## 1 Joy Place (CBL #045 E049; ID#2017-128) comments

This email outlines some concerns around the plan for the building being constructed at 1 Joy Place (CBL #045 E049; ID#2017-128).

WOOD FENCE DETAIL [TYPE 'B'] HTS

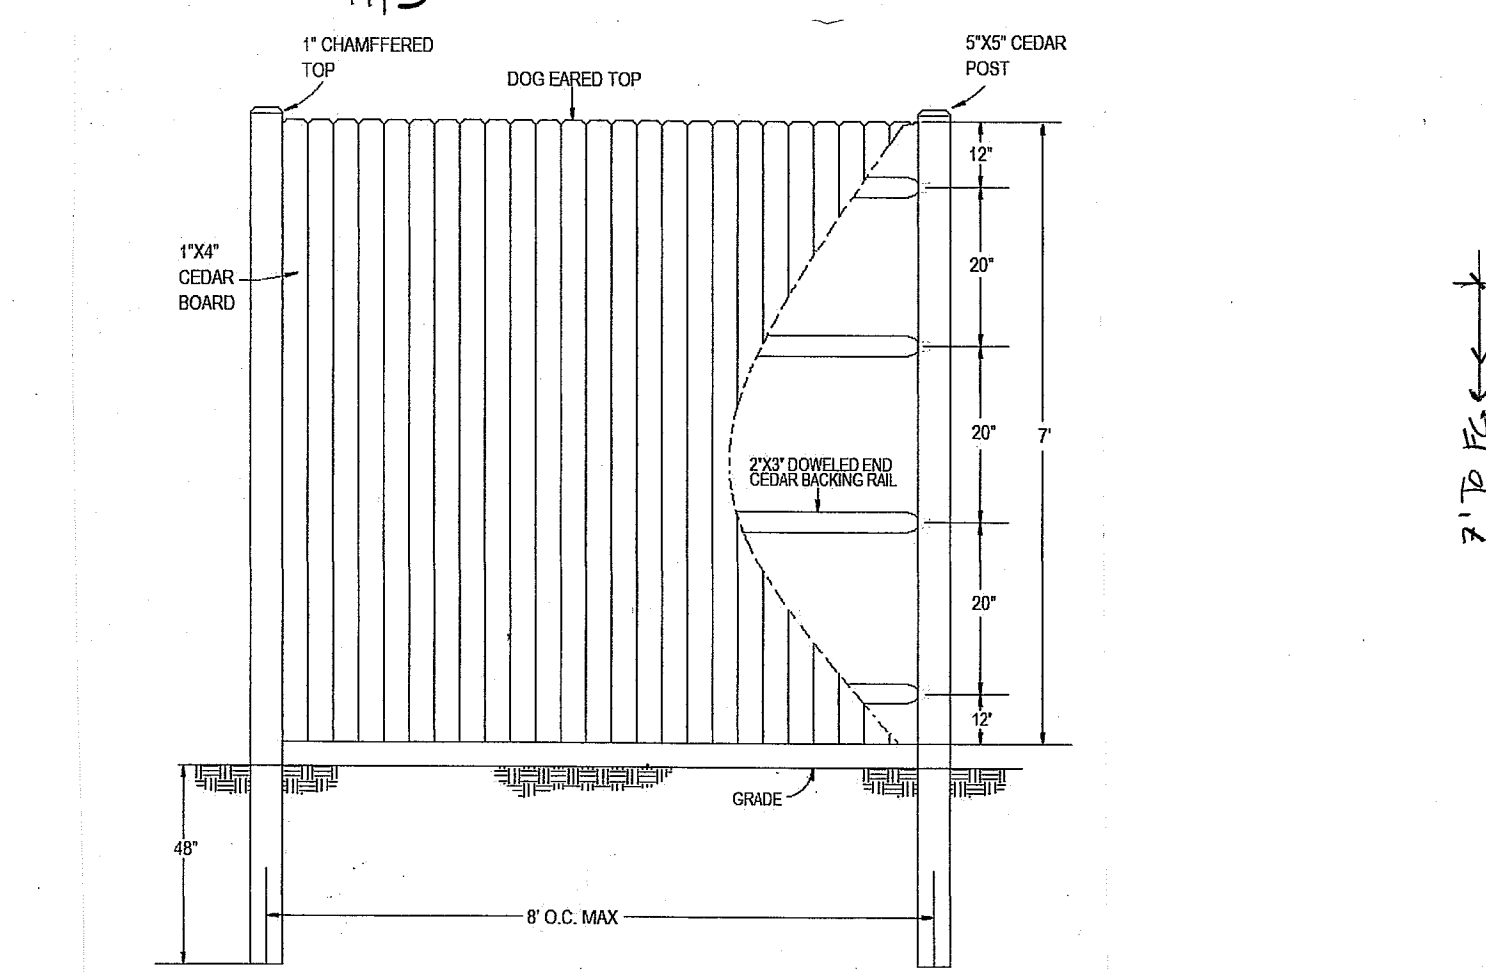
We also have some notes on the fence that is being build to separate the passageway and Joy Place building from our back yard.

- Use a fence on our property line that is **7' or taller** and that has **no gaps between fence boards** (to maintain visual privacy between the passage between our buildings and our back yard).
- Use **solid material (wood) for fence gate** material, also for privacy.
- **Relocate gate 3-6 feet from the corner where it is located** on the plan (existing plantings on our property are in the way if it stays the corner location and would obstruct passage)
- Confirm that our deeded right of way is a clear **12' wide** and allows for vehicle passage.

L.1

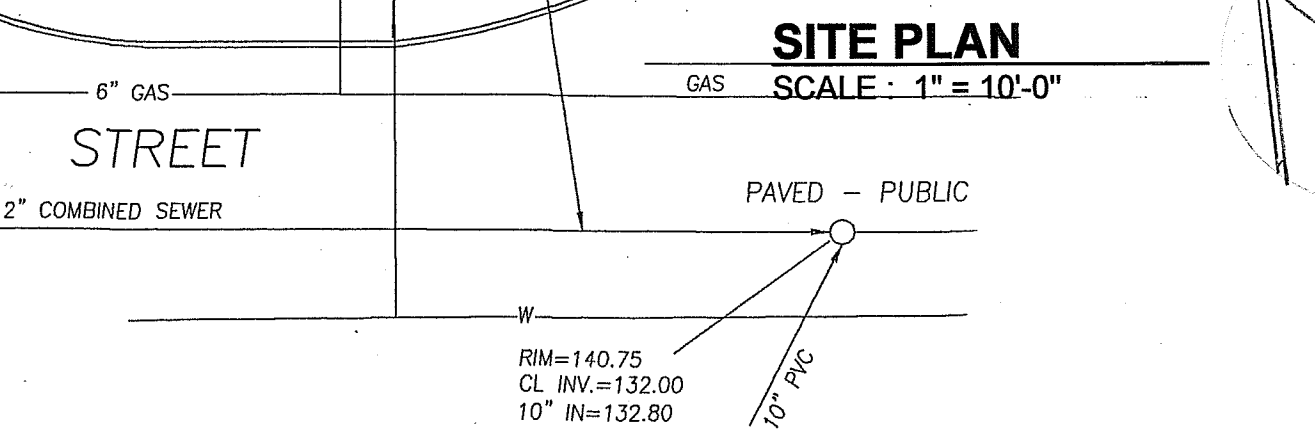
Looking at the submitted plan, it is not clear that the passageway remains sufficiently open. There wasn't a scale on the landscaping plan, so I couldn't measure it to confirm the width. I know it is tight with 1 Joy Place structure being built right up to the edge of right of way.

I also could not tell if the low-growing vinca is actually growing in a raised bed that would impinge on the travel lane.

We ask that the paving and landscaping keep the right of way a clear 12' wide, allowing for vehicles, without running into/over planting beds.
